FINAL GRADING AND EROSION CONTROL PLANS
FALCON MEADOWS AT BENT GRASS FILING NO. 4
FALCON, CO 80831 - EL PASO COUNTY
CHALLENGER COMMUNITIES, LLC

PUDSP-20-005 (FALCON MEADOWS AT BENT GRASS PRELIMINARY PLAN)
SF-22-XXX (FALCON MEADOWS AT BENT GRASS FILING NO. 4)

Engineering Review
08/19/2022 2:51:35 PM
jdrice
JeffRice@elpasoco.com
(719) 520-7877
EPC Planning & Community
Development Department

POND A – PLAN VIEW

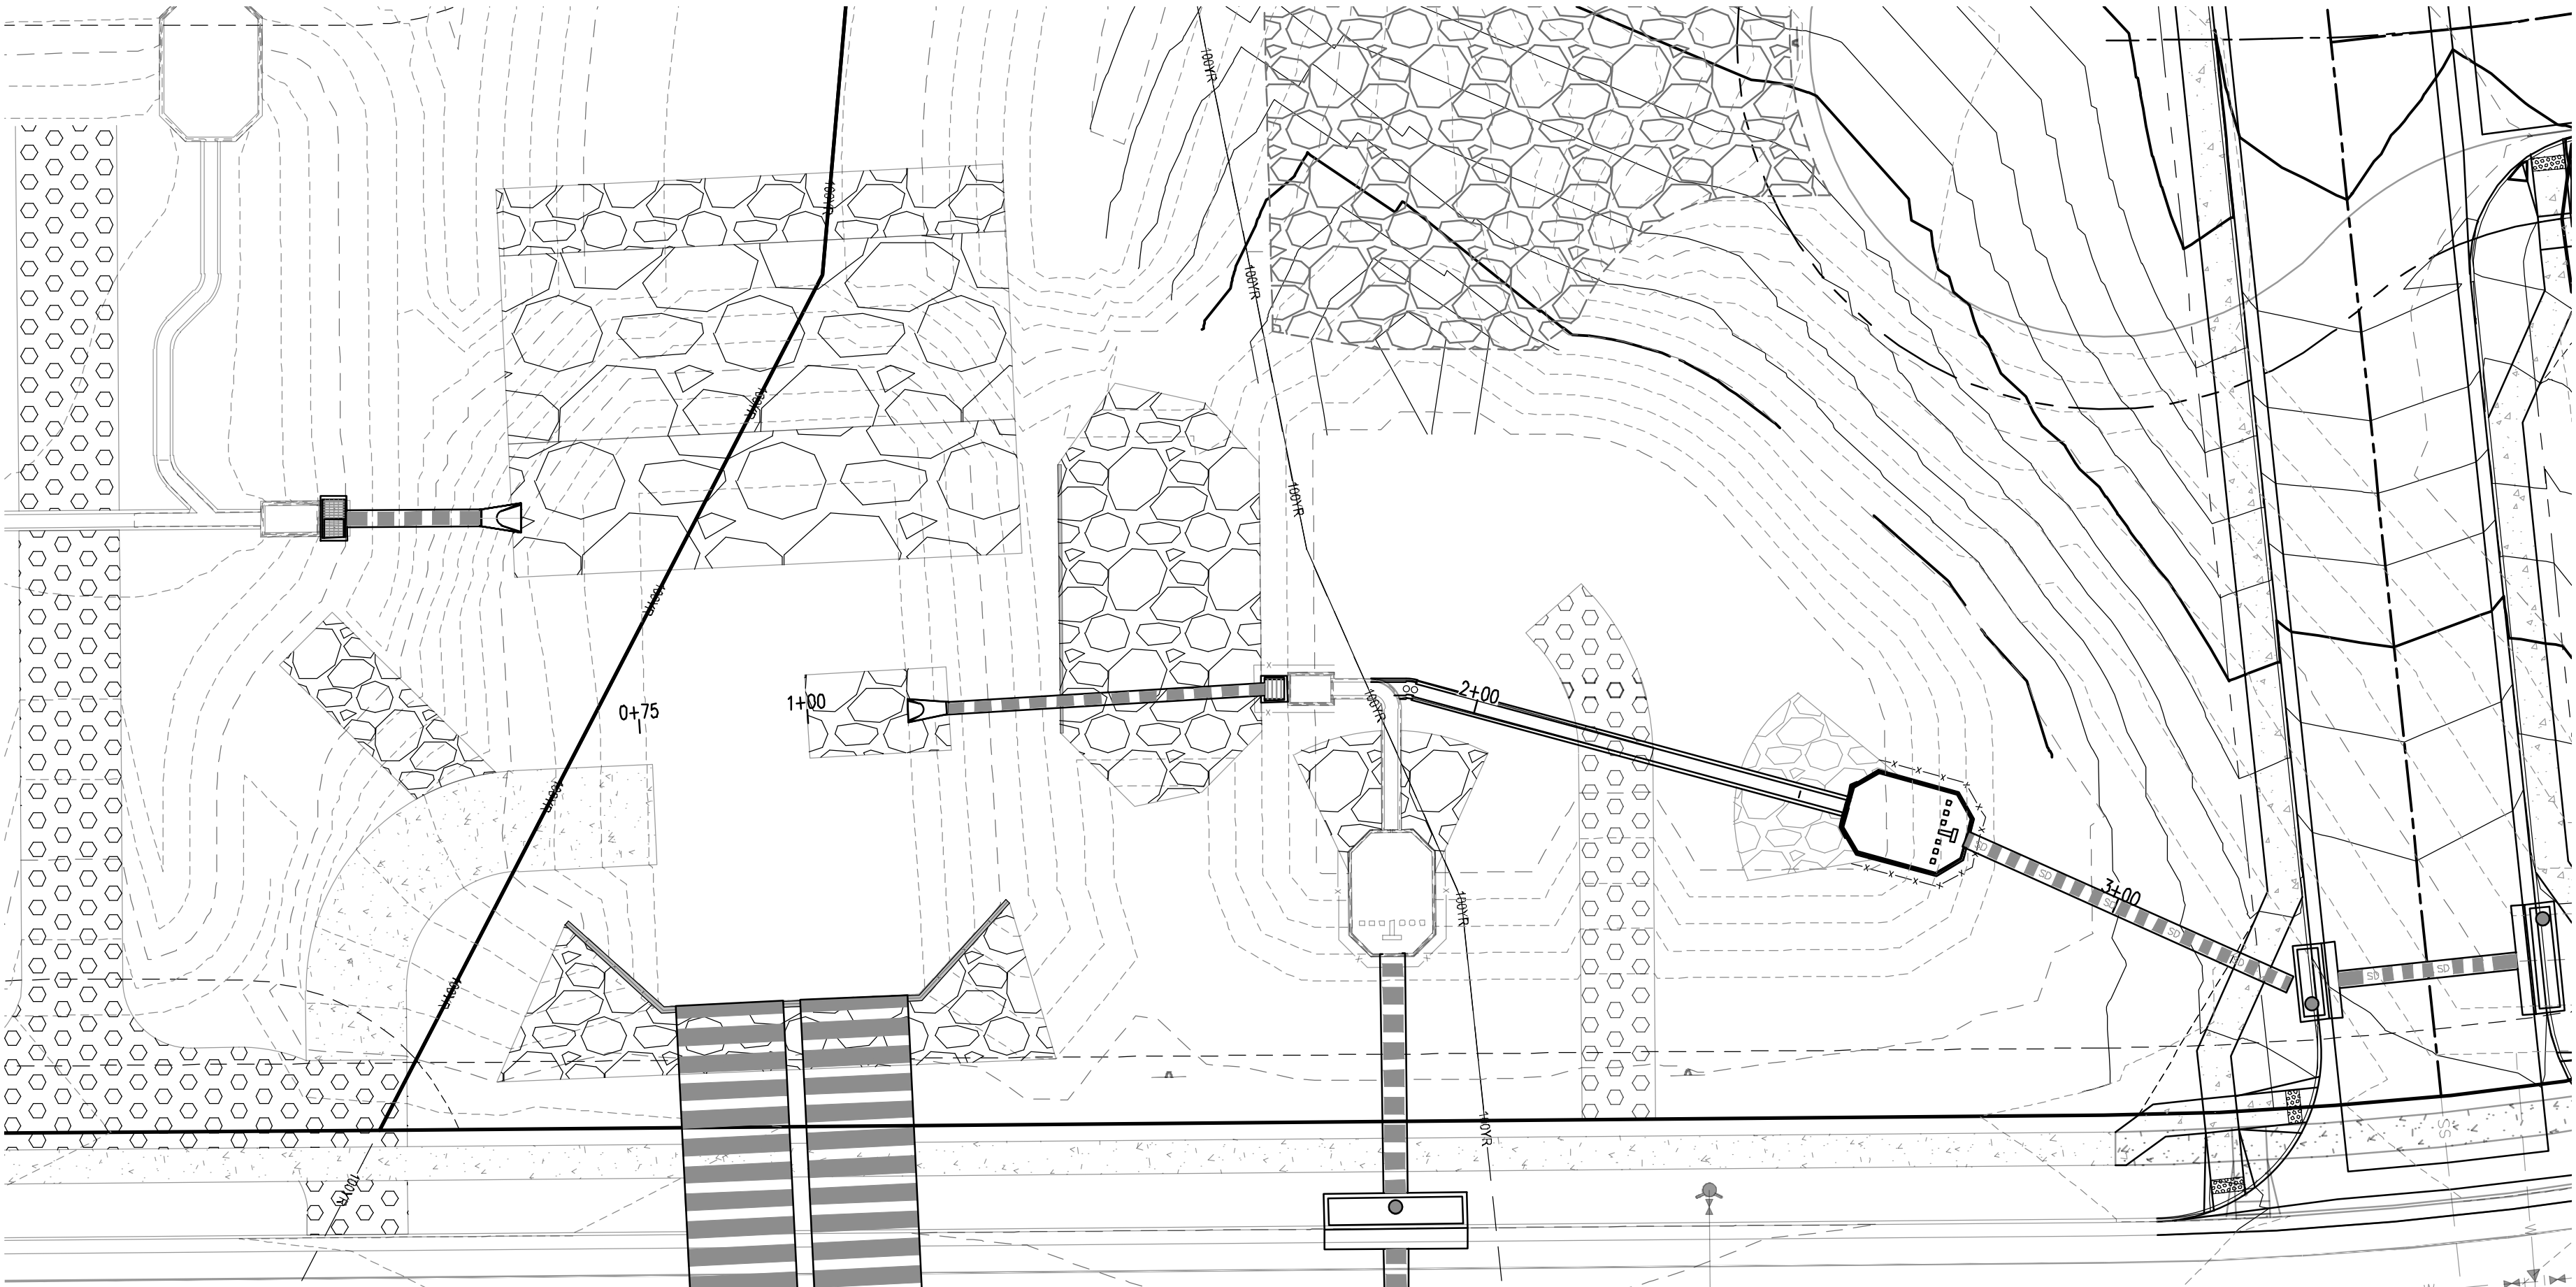
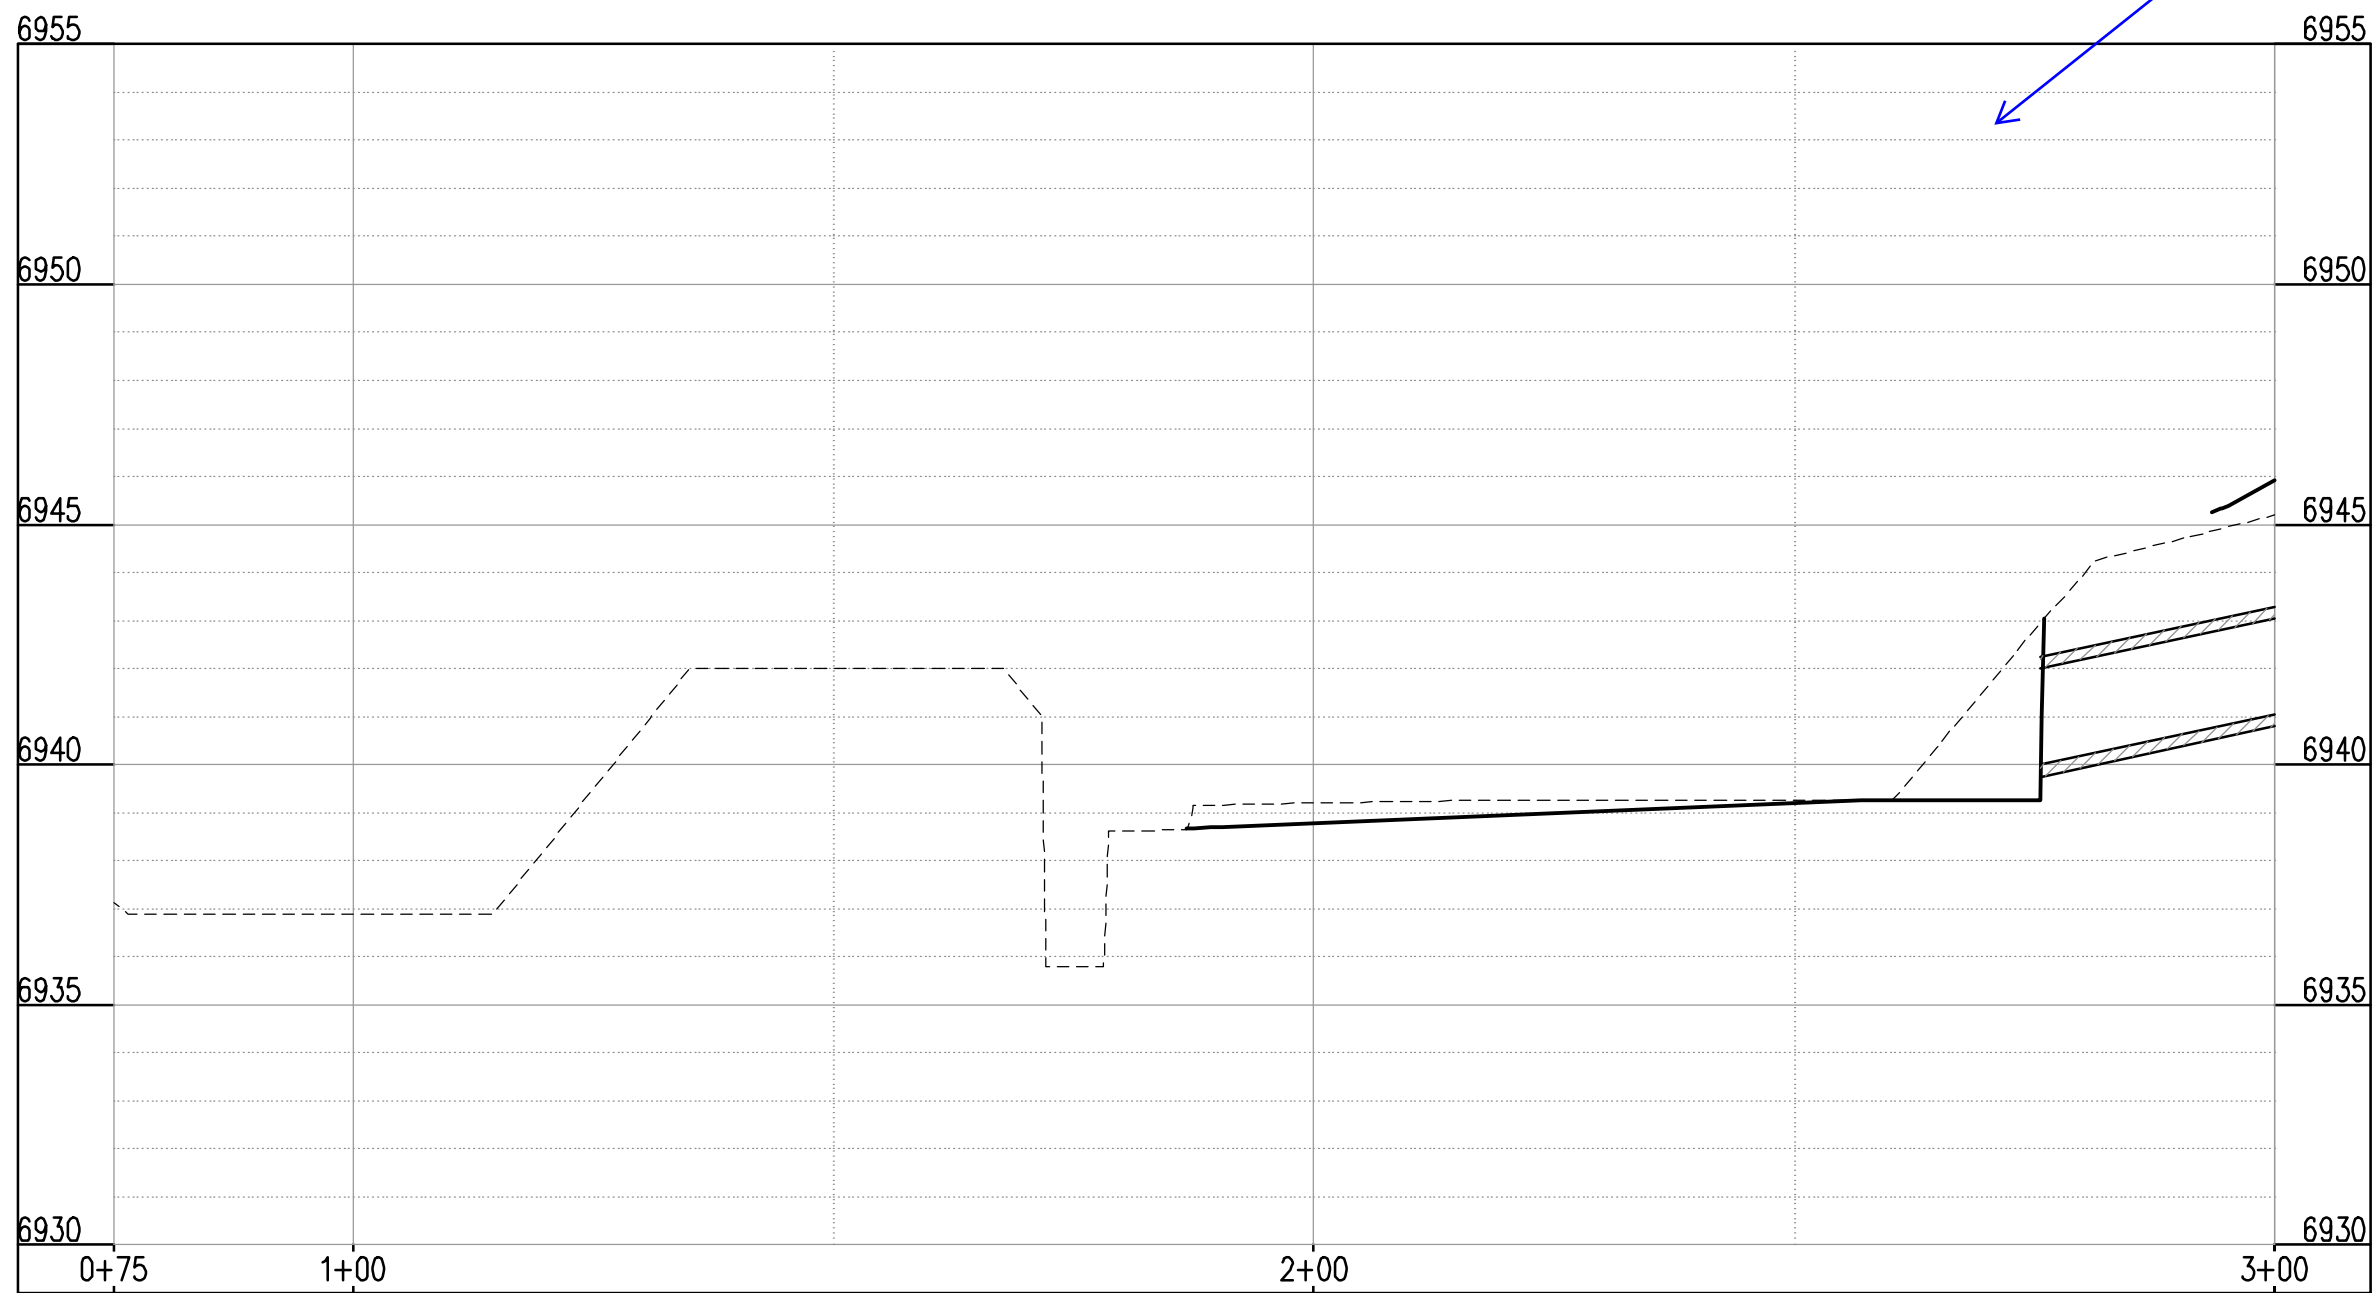
Provide forebay design and details

GRADING & EROSION CONTROL TYPICAL SECTIONS

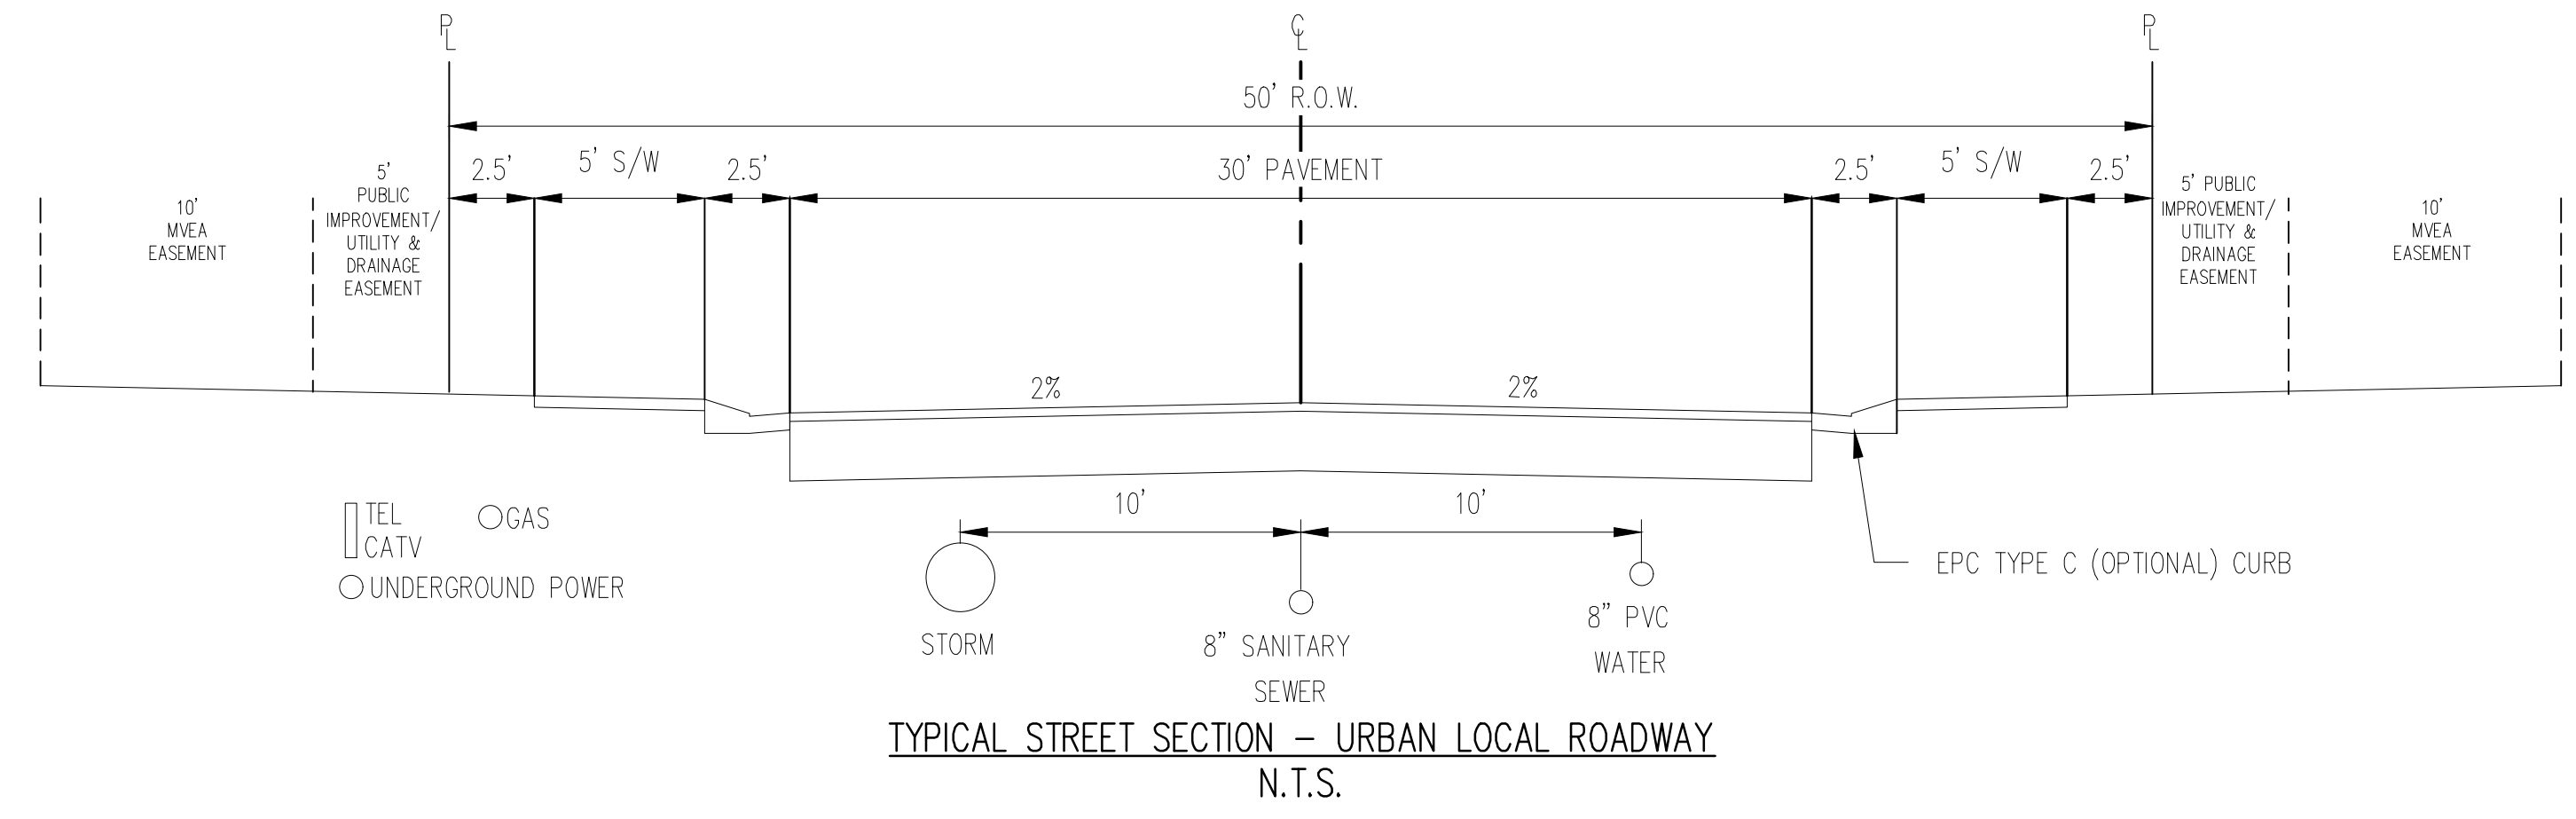
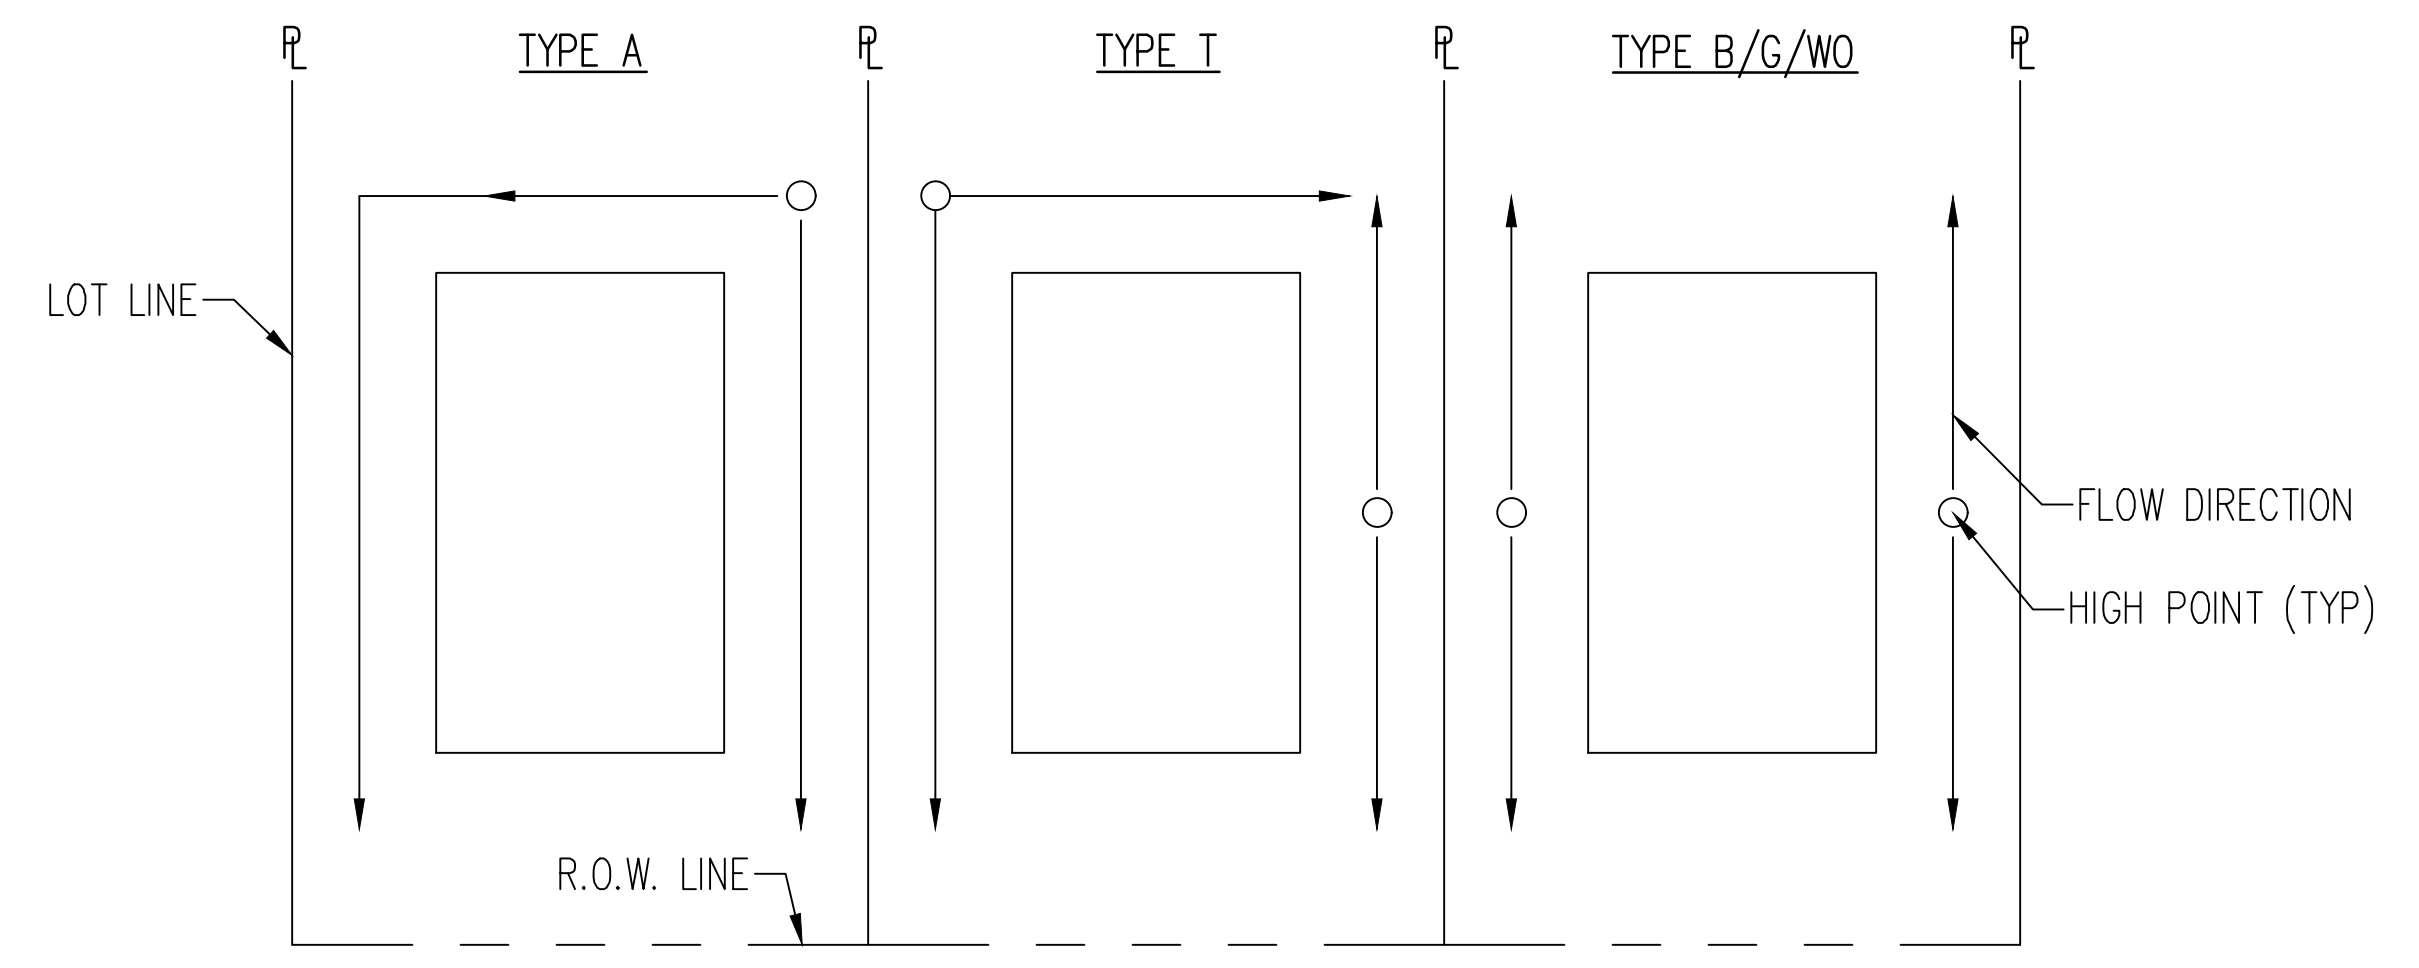
Add note referencing G4.1 for swale cross-sections
